Re: 149-151 Spring Street (Carlton Court)

Your building permit application to change the use from 19 apartments to 21 apartment units, at the above address is APPROVED subject to the following:

FIRE ALARM SYSTEM LAYOUT - FIRST FLOOR
SCALE: 1/8"=1'

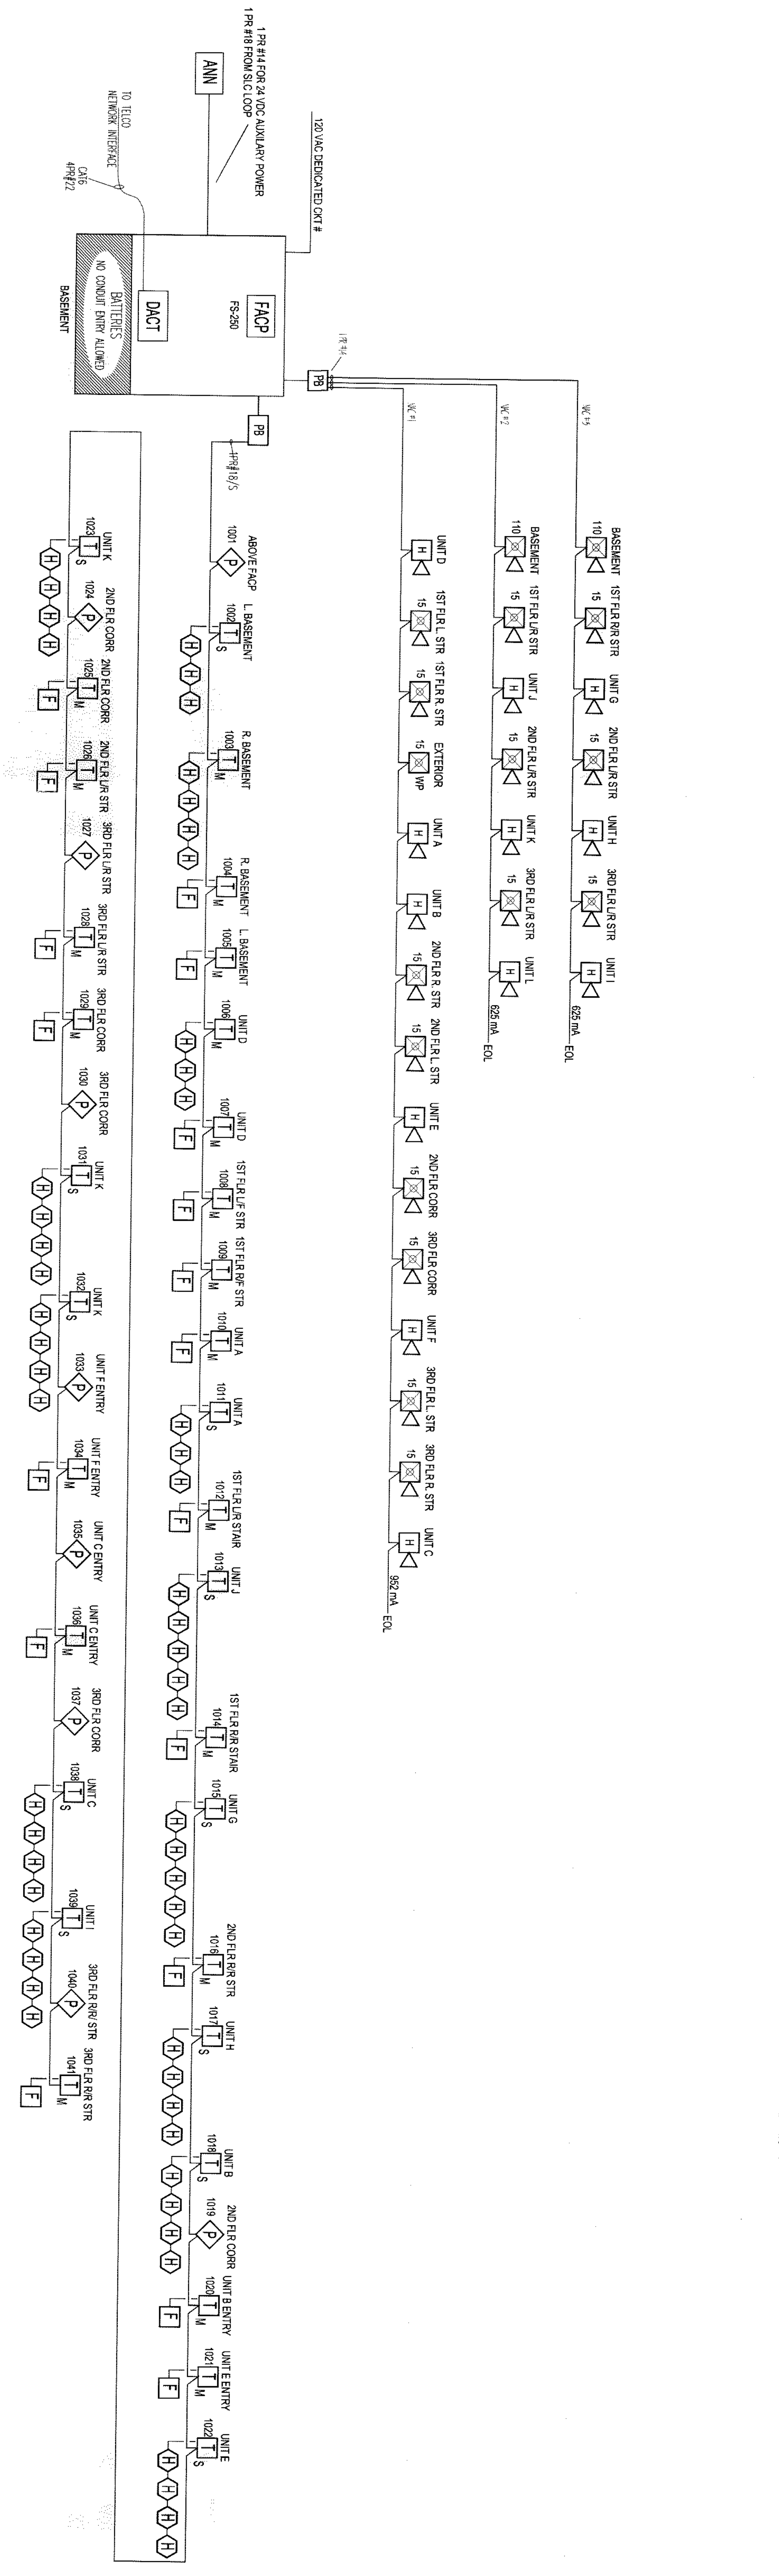
- (1) Pull stations for fire alarm on the first floor shall be placed at the first floor exit.
- (2) Provide 2nd means of egress from first floor units. (Chapter 314 Municipal Code) *see page 11 of plan*
- (3) Apartment separation at building #147 shall be a two (2) hour fire separation wall. *see plan*
- (4) All exit doors shall swing in the direction of exit travel. *see plan*
